Please ask for: Ms Iqraa Malik
Email: iqraa.malik@terraquest.co.uk
Telephone: 01212341390
Our Ref: FG/166/20/HH
Your Ref:
Date: 14th January 2021

Application for Planning Permission for Works or Extension to a Dwelling

Development: Creation of 2 habitable rooms in existing garage and remodelling of GF bedroom to accessible bathroom to accommodate dependent family member. Extension and remodelling of existing rear conservatory to accommodate kitchen and store room. Erection of timber clad storage container/ outhouse on front drive.

Location: 5 Ferringham Way Ferring BN12 5NG

Project
Elevations: Container Storage, sheet 1

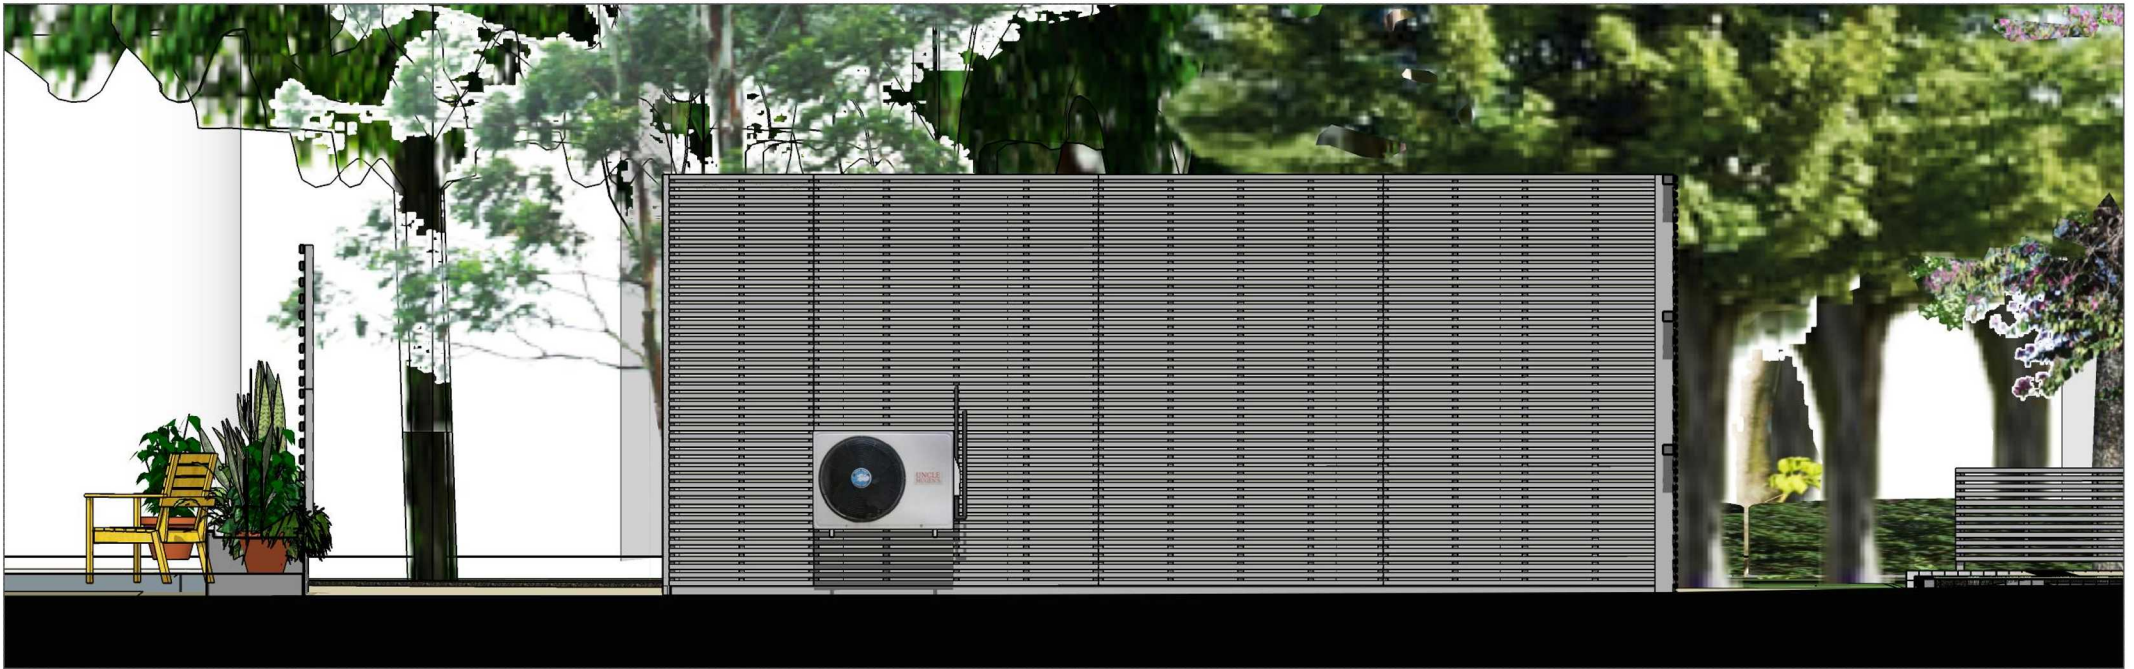
Elevations: You are required to provide all elevations of the outbuilding.

Project
Site Plan, Proposed

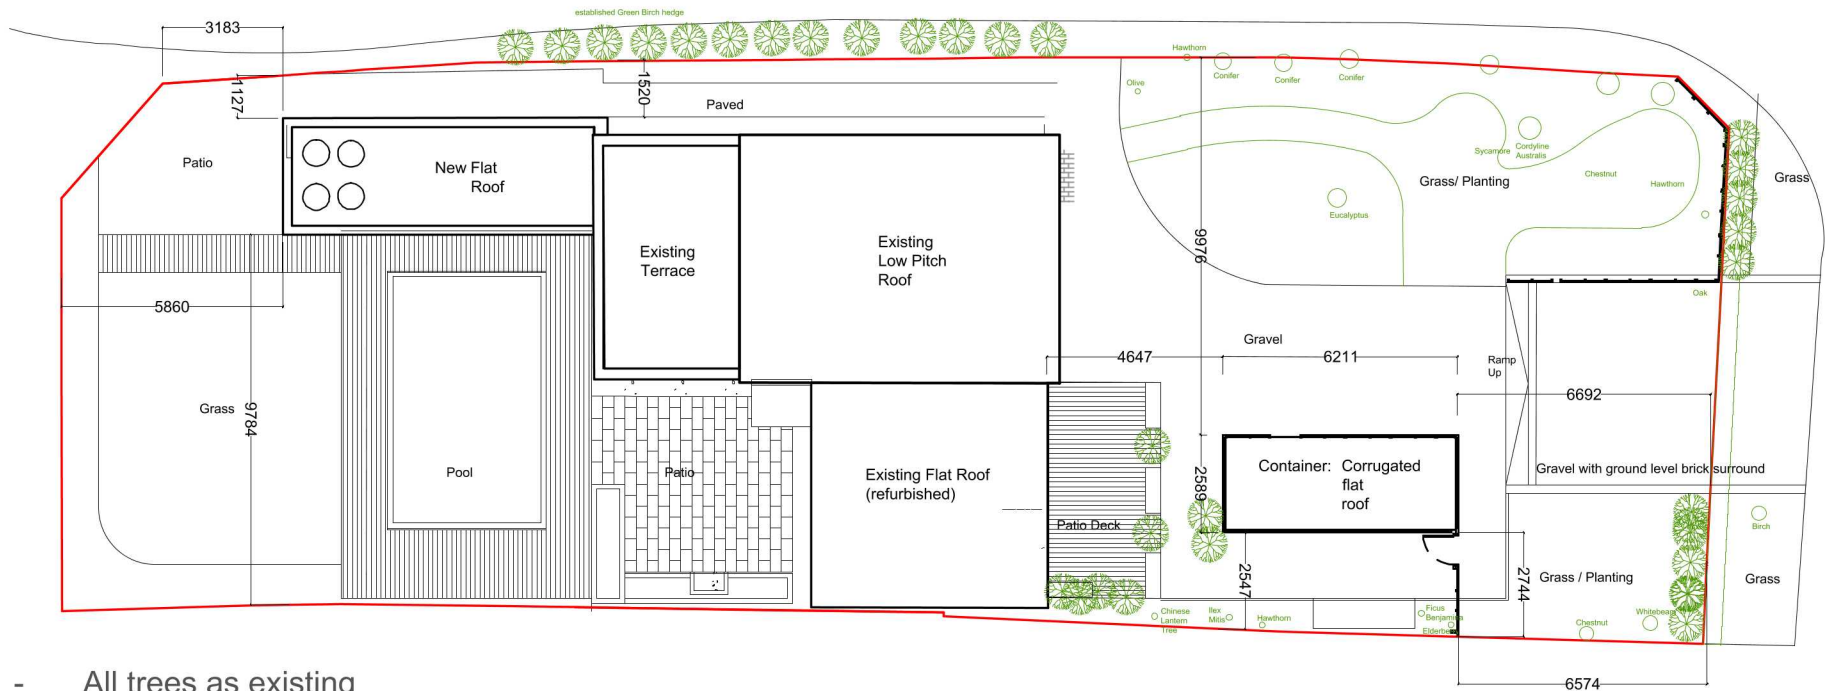
You are required to include dimensions from the proposed extensions and alterations to all site boundaries.
